# APPENDIX A – SUBMISSIONS REGISTER

## Public Authority and Agency Submissions

AR-ABC-A1-01

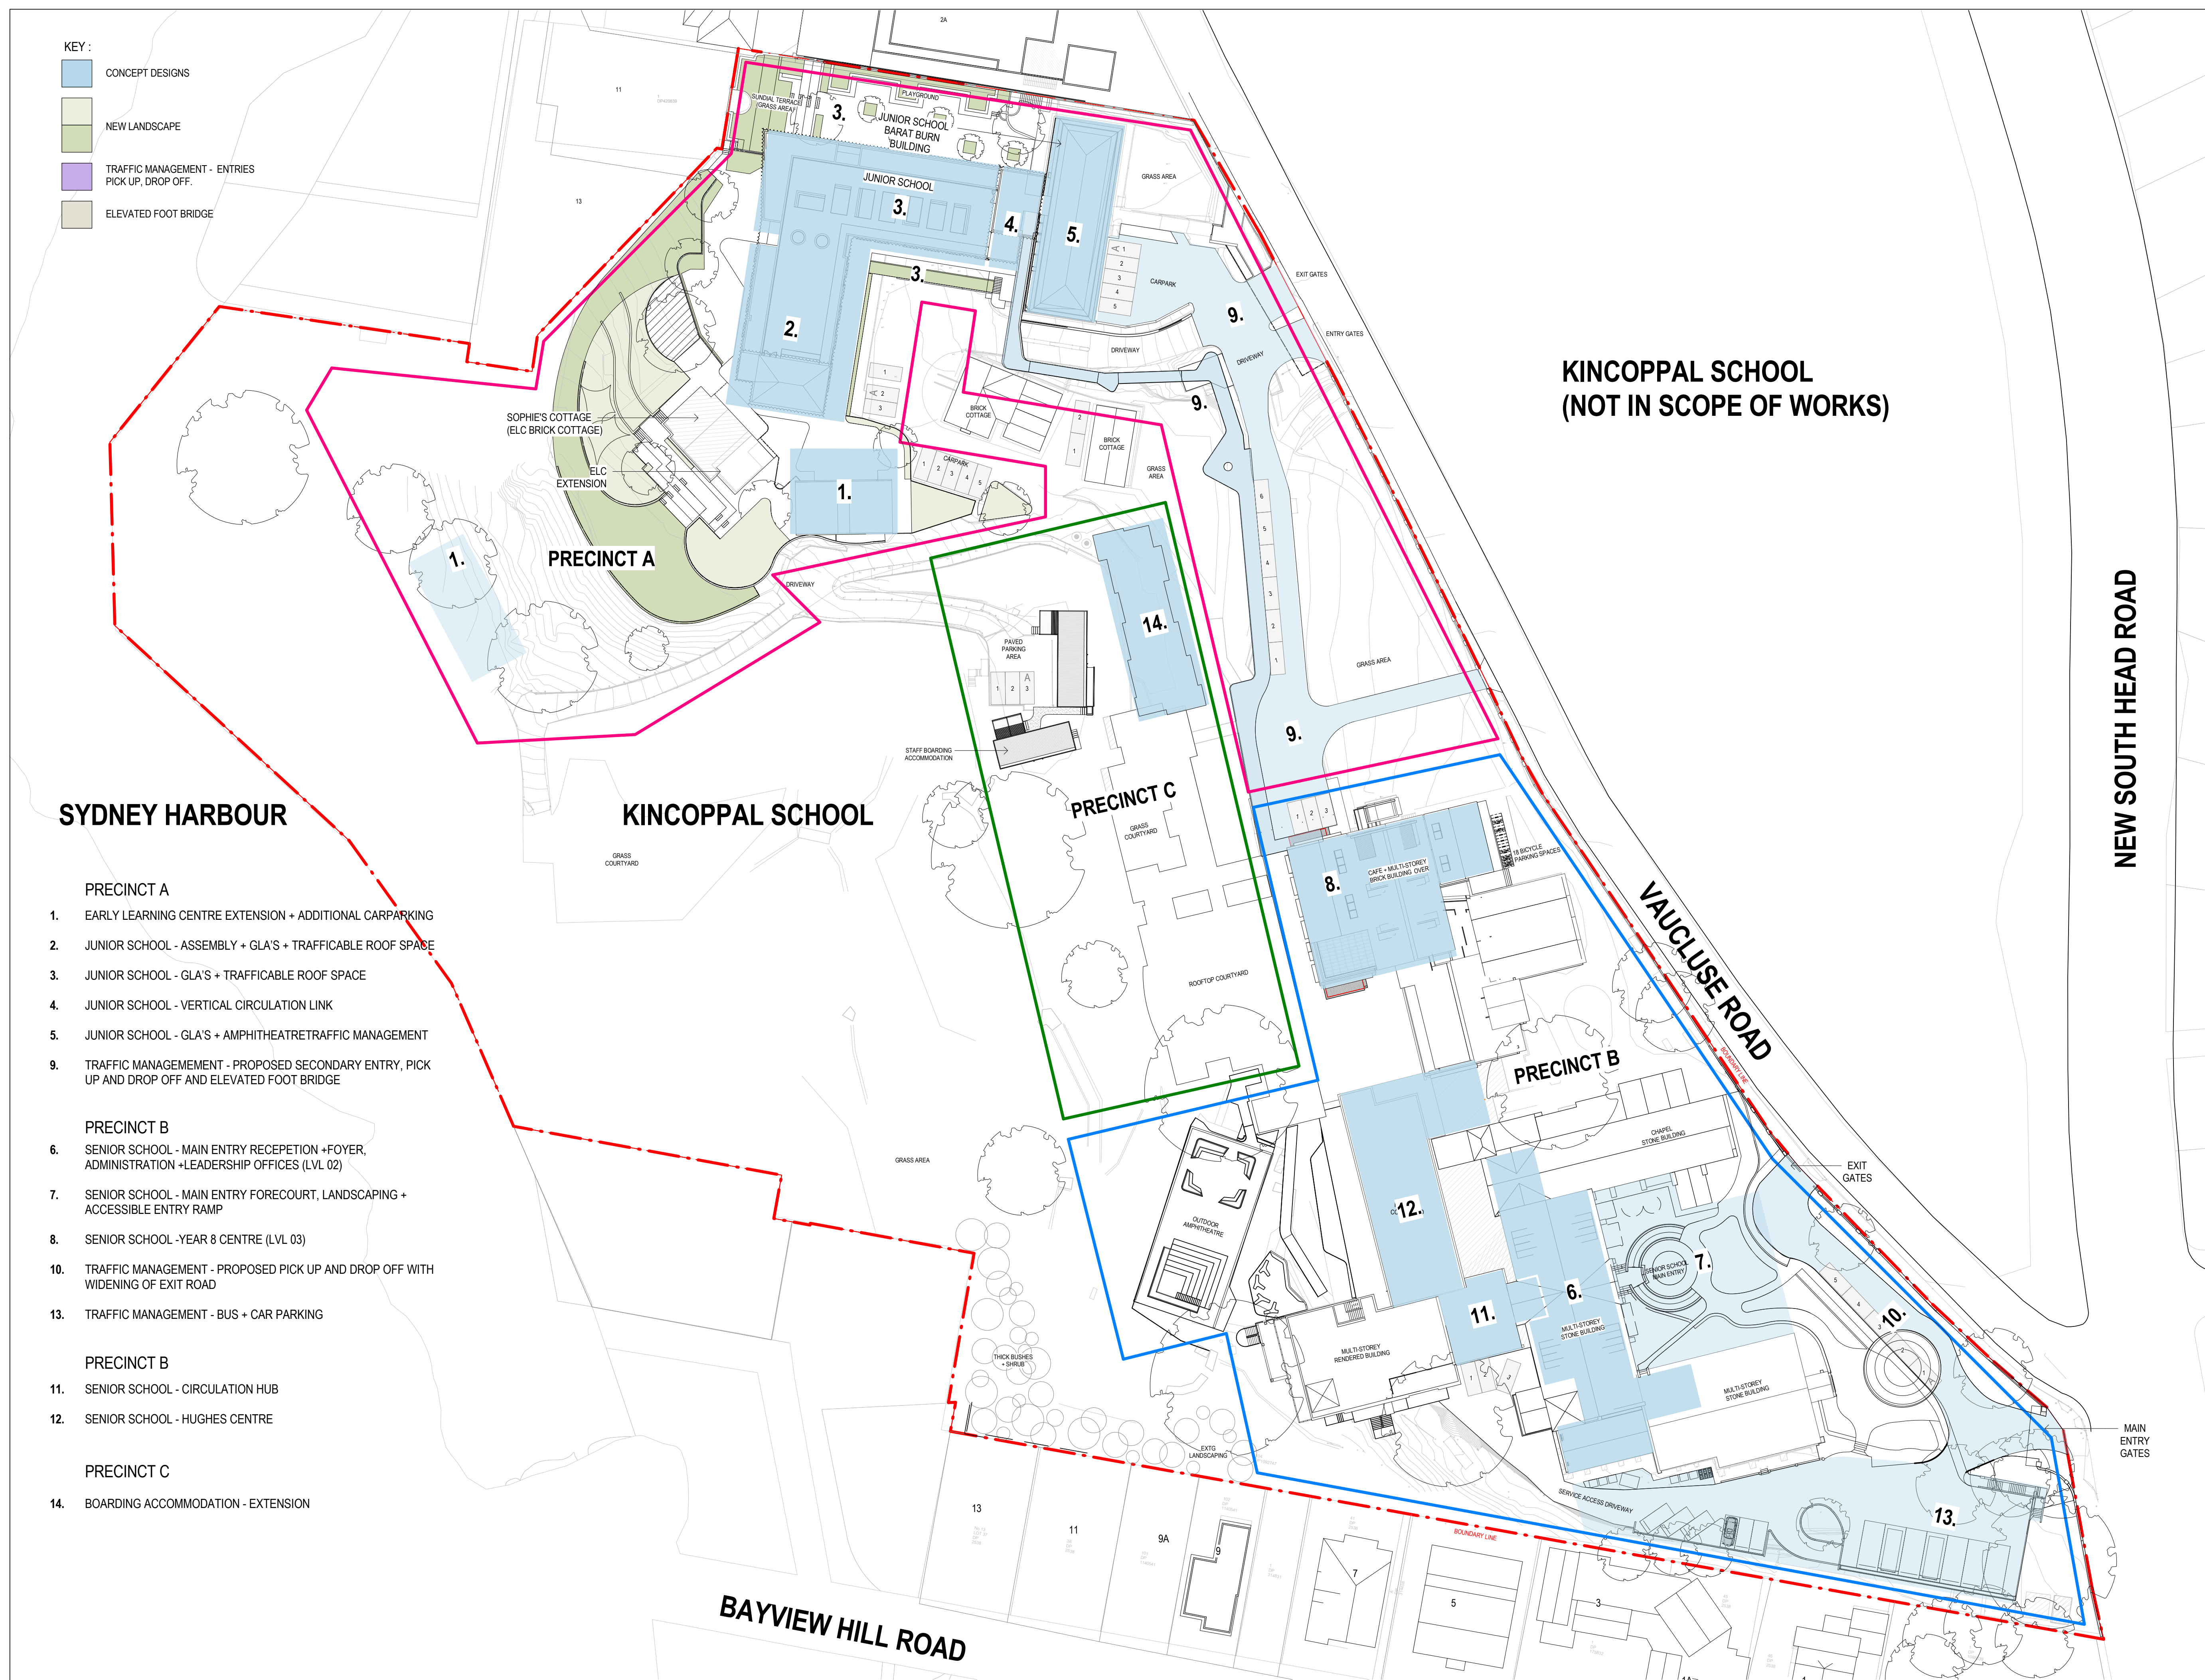
The proposal includes additional parking adjacent to the ELC outdoor play area. However, while these spaces are shown on the Proposed Site Plan (AR-ABC-A1-01 Rev. 4), these spaces have not been identified on the Stage 1 Detailed Plans for the ELC (A-A0-00-A-Y1-03). The architectural plans should be updated.	The Detailed Architectural Plans have been updated to accurately reflect the provision of car parking spaces adjacent to the ELC outdoor play area, as well as across the entire site. Refer to the Concept Architectural Plans (Site Wide) at <b>Appendix D1</b> and the Detailed Architectural Plans (ELC) at <b>Appendix E1</b> for further details.	<b>Appendix D1 and E1</b>
<b>11. Stormwater Concept</b>		
The Department notes a civil engineering report and civil drawings set have been provided. However, revised civil drawings, and an addendum to the report, should be submitted that adequately details how stormwater within the entire site is managed.	A Stormwater Concept for the entire site is included within the Revised Civil Plans. The Civil Engineering Report has also been updated to include further information regarding drainage details associated with the proposal, including stormwater and drainage infrastructure. Refer to <b>Appendix J</b> and <b>Appendix K</b> for details.	<b>Appendix J and K</b>

AR-A-B1-00(B)	3
---------------	---

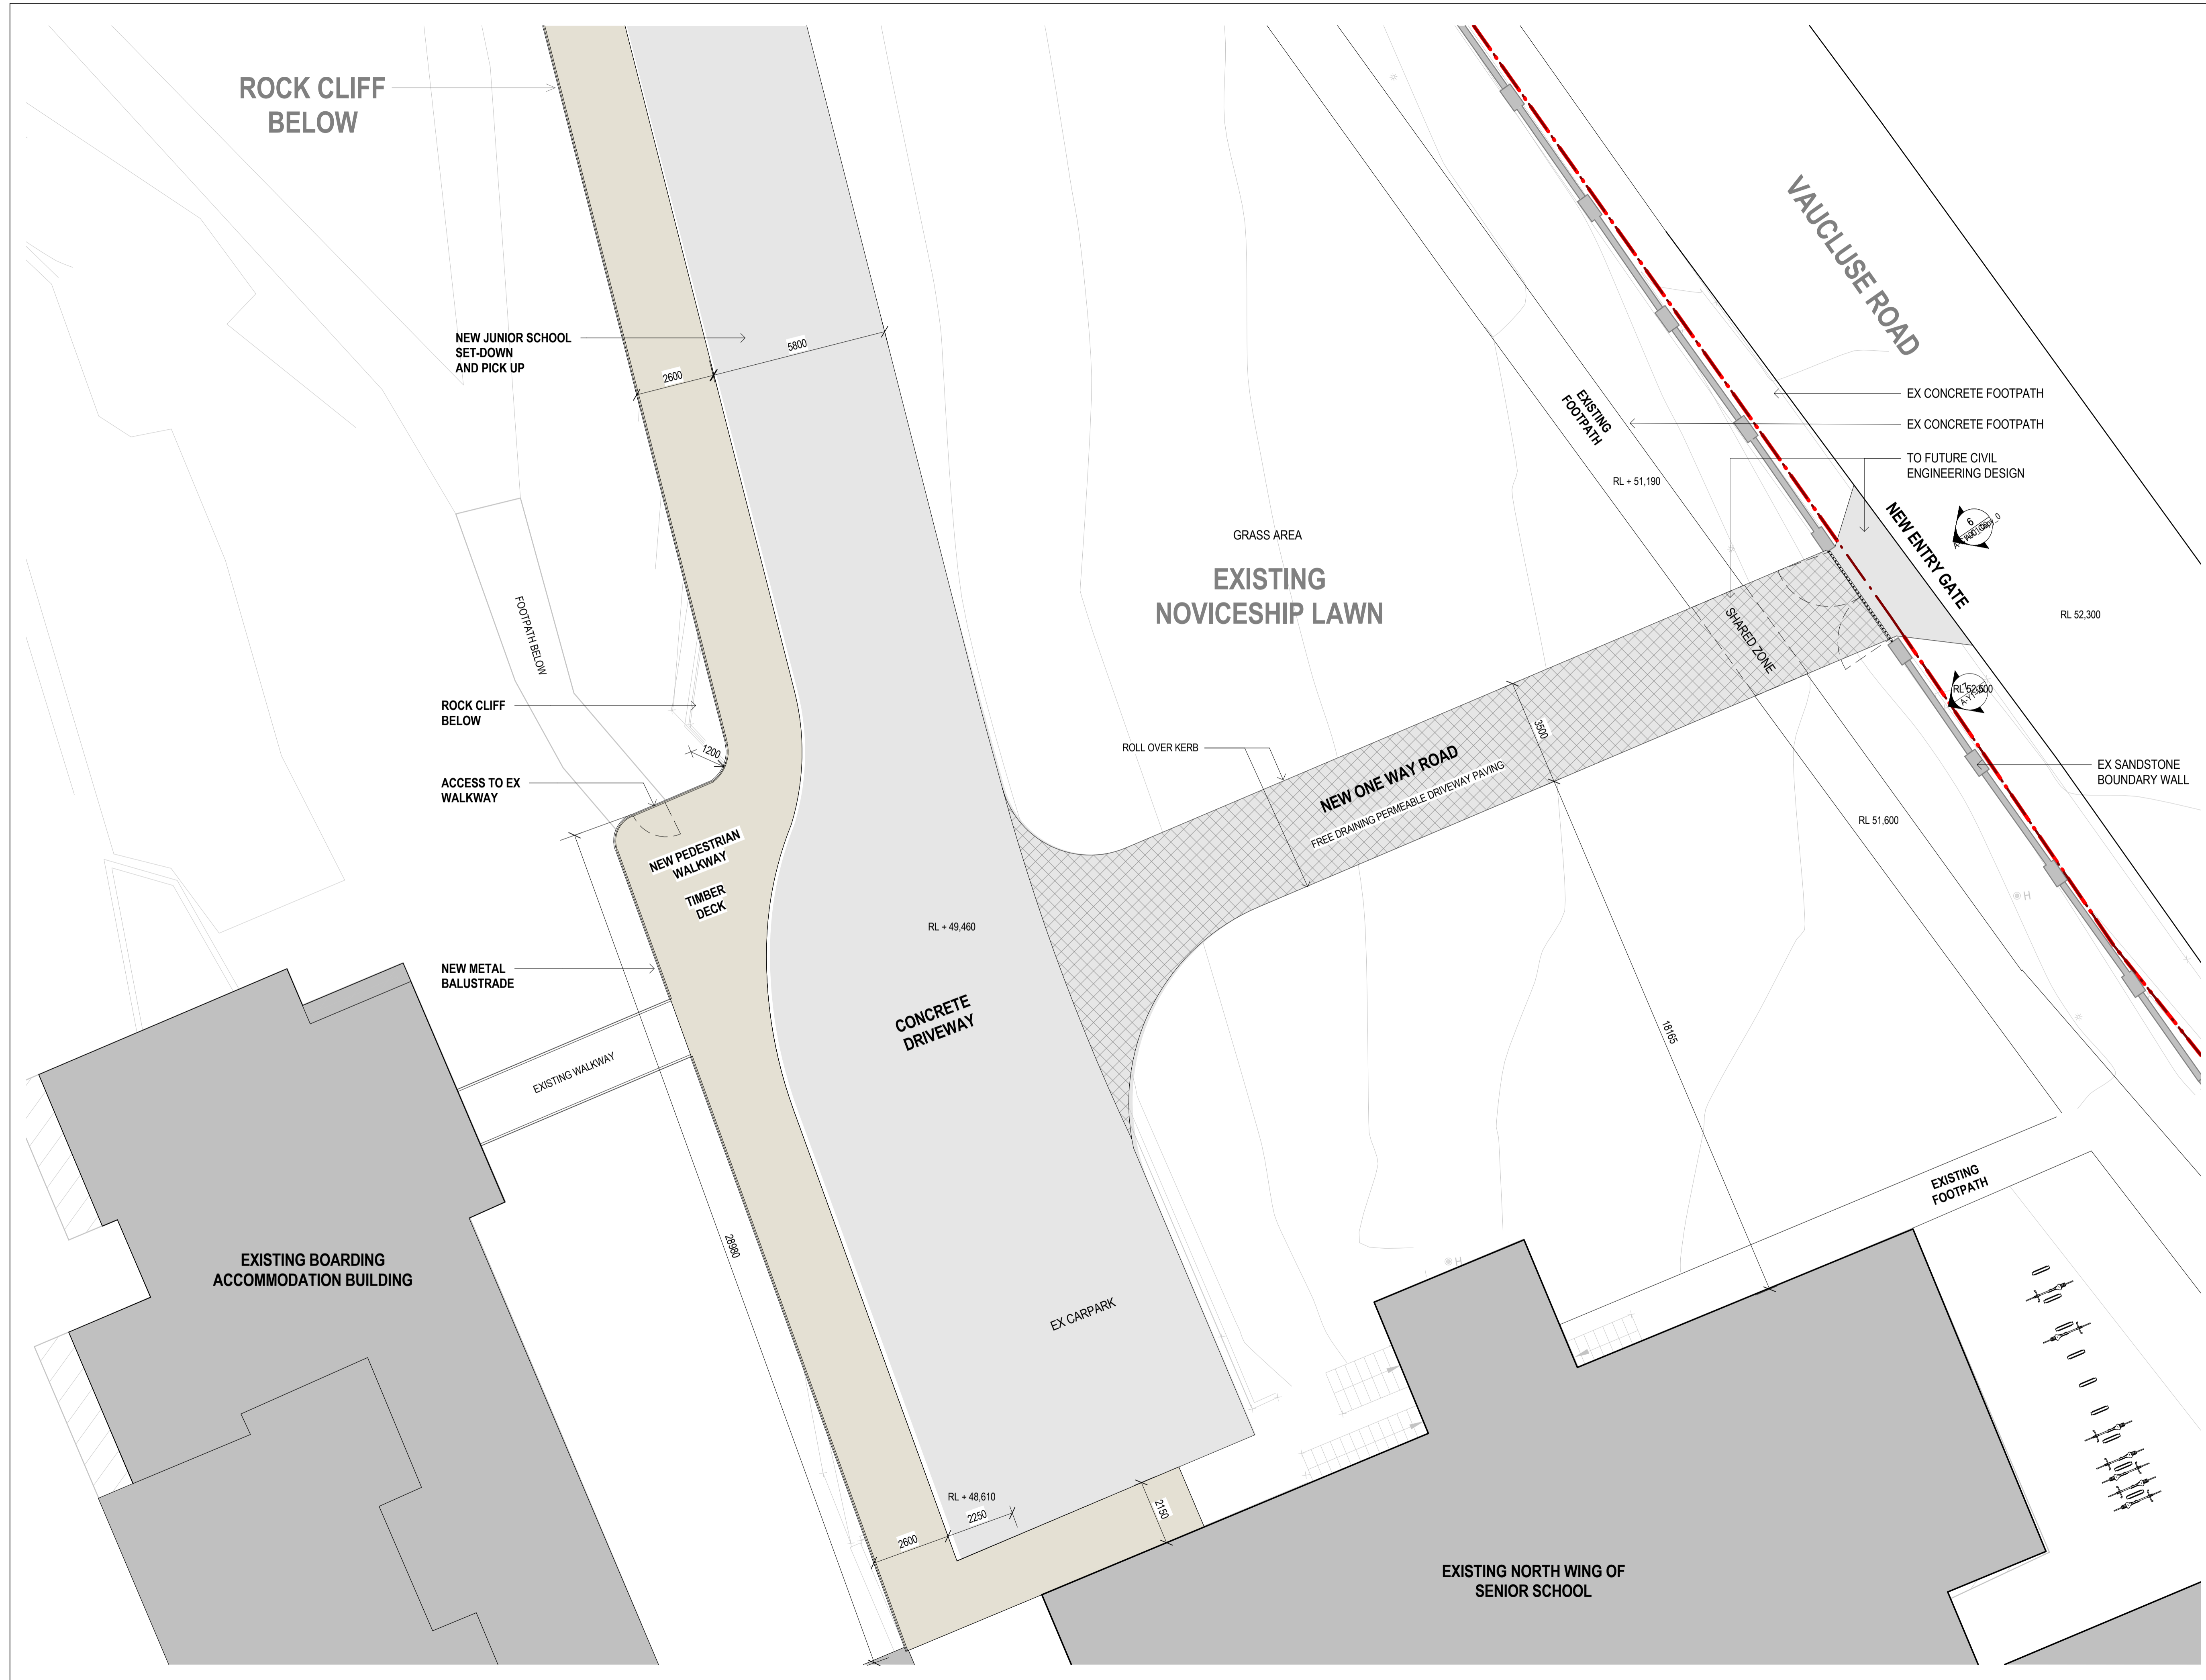
4. Inconsistencies Between Documentation		
The Civil Engineering Report (Appendix N) notes that a bund is required on the junior school driveway to prevent overland flow. The Civil Plans and Detailed Architectural Plans should identify this bund.	Drawing No. AR-A-B1-00(A) of the Detailed Architectural Plans (Junior School and ELC) has been updated to illustrate the bund required to the junior school driveway. Drawing No. 19949_DA_C110 of the Civil Plans have also been updated to illustrate the location and design of the proposed bund. Refer to <b>Appendix E1</b> and <b>Appendix J</b> for further details.	<b>Appendix E1 and J</b>
